STATE OF NORTH CAROLINA
DEPARTMENT OF TRANSPORTATION

Addendum No. 1

RE: Contract ID C203452
WBS # 5CR.10351.13 Etc.
State Funded

NC-39 From NC-98 To US-64 WB On-Ramp, NC-98 From NC-39 To
Nash County Line and 6 Sections Of Secondary Roads

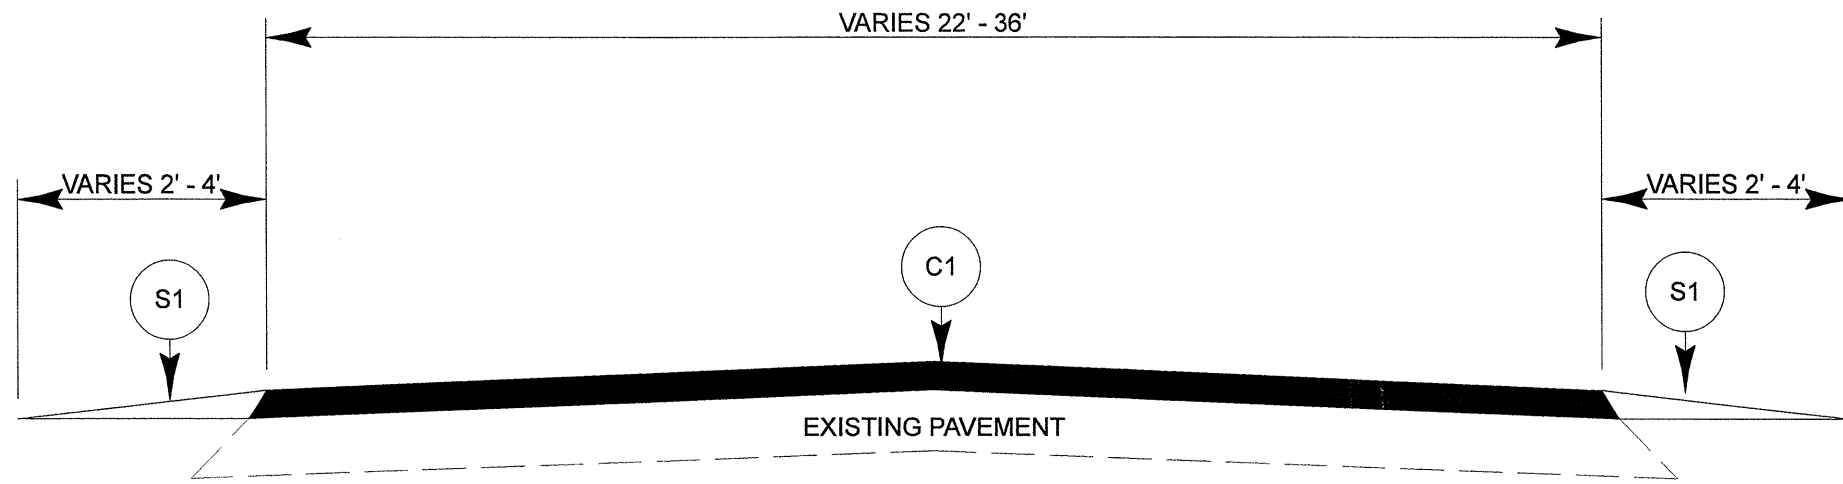
On Sheet No. 1, new Map #8 has been added. Please void Sheet No. 1 in your sketch maps and staple the revised Sheet No. 1 thereto.

TYPICAL SECTION NO. 1

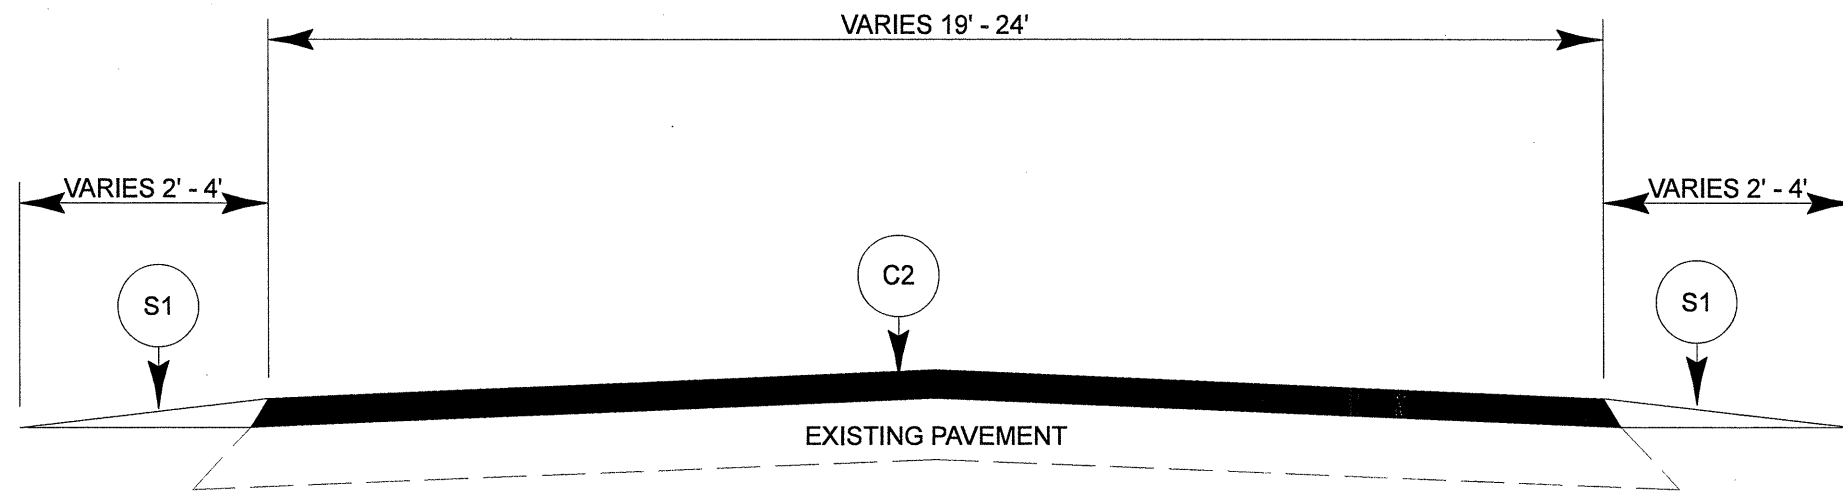
On Sheet No. 2, Typical Section No. 1 was revised to show that the width varies from 22'-36'. Please void Sheet No. 2 in your sketch maps and staple the revised Sheet No. 2 thereto.
